Date: 18-Nov-2025
Our Ref: 2025/92797

**TOWN AND COUNTRY PLANNING ACT 1990
TOWN AND COUNTRY PLANNING (GENERAL PERMITTED DEVELOPMENT) (ENGLAND)
ORDER 2015 – SCHEDULE 2, PART 1, CLASS A.1 (g)
AT: Laneside, Scopsley Lane, Whitley, Dewsbury, WF12 0NG
Prior notification for single storey rear extension**

Drawing Title
Proposed Elevations

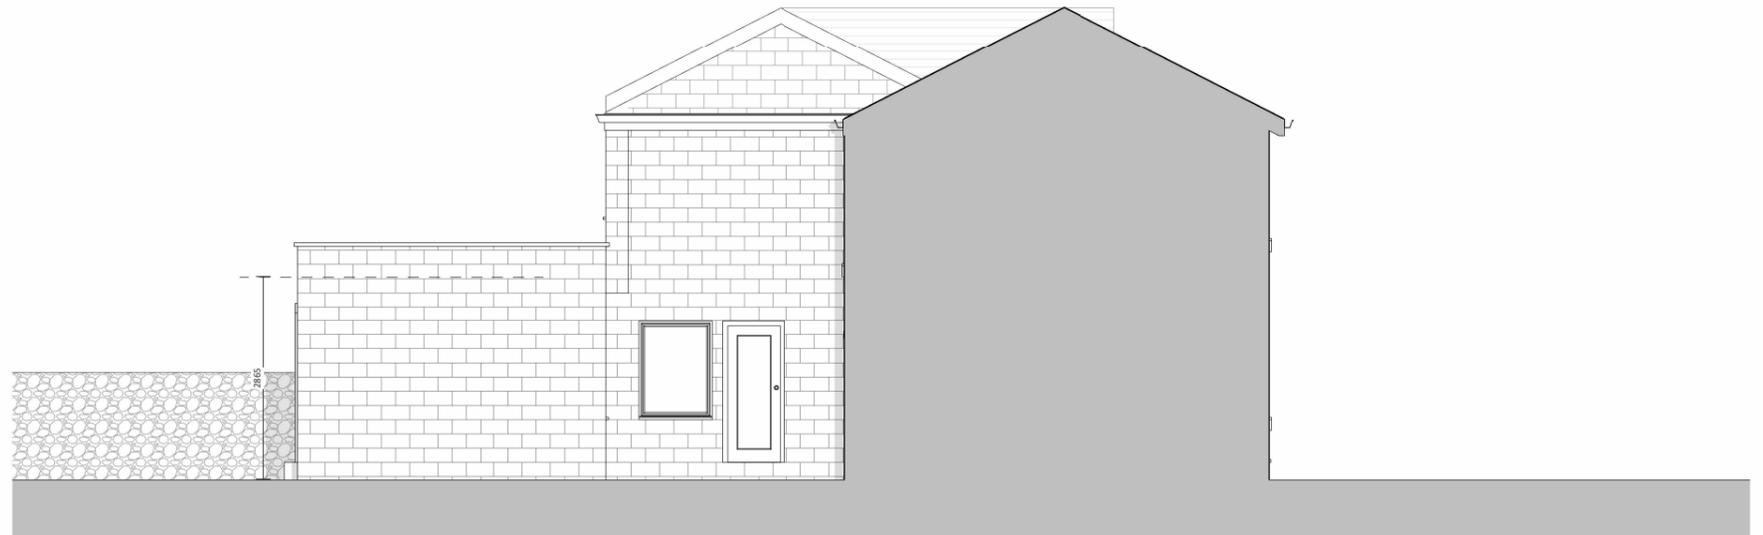
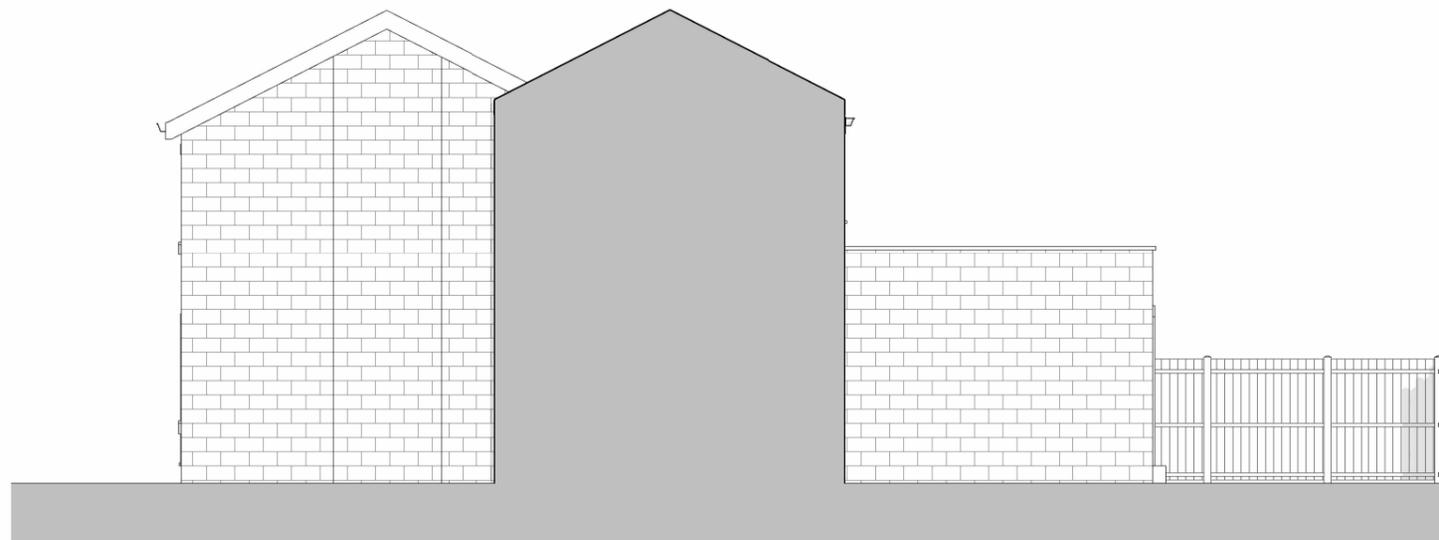
The proposal is for erection of single storey rear extension. The extension projects 4.36m beyond the rear wall of the original dwellinghouse. The maximum height of the extension is 3.35m, the height of the eaves of the extension is 2.86m

The proposed enlargement does not benefit from a general planning permission under Article 3(1) and Class A, Part 1, Schedule 2 of the Town and Country Planning (General Permitted Development)(England) Order 2015(as amended) as the proposed enlargement adjoins an existing two storey enlargement to the original dwellinghouse where the combined two and single storey enlargements would have more than one storey and project more than 3 metres from the rear of the original dwellinghouse and be within 2 metres of the boundary with an eaves height in excess of 3 metres contrary to sub-paragraphs (h), (i) and (ja) of Class A.
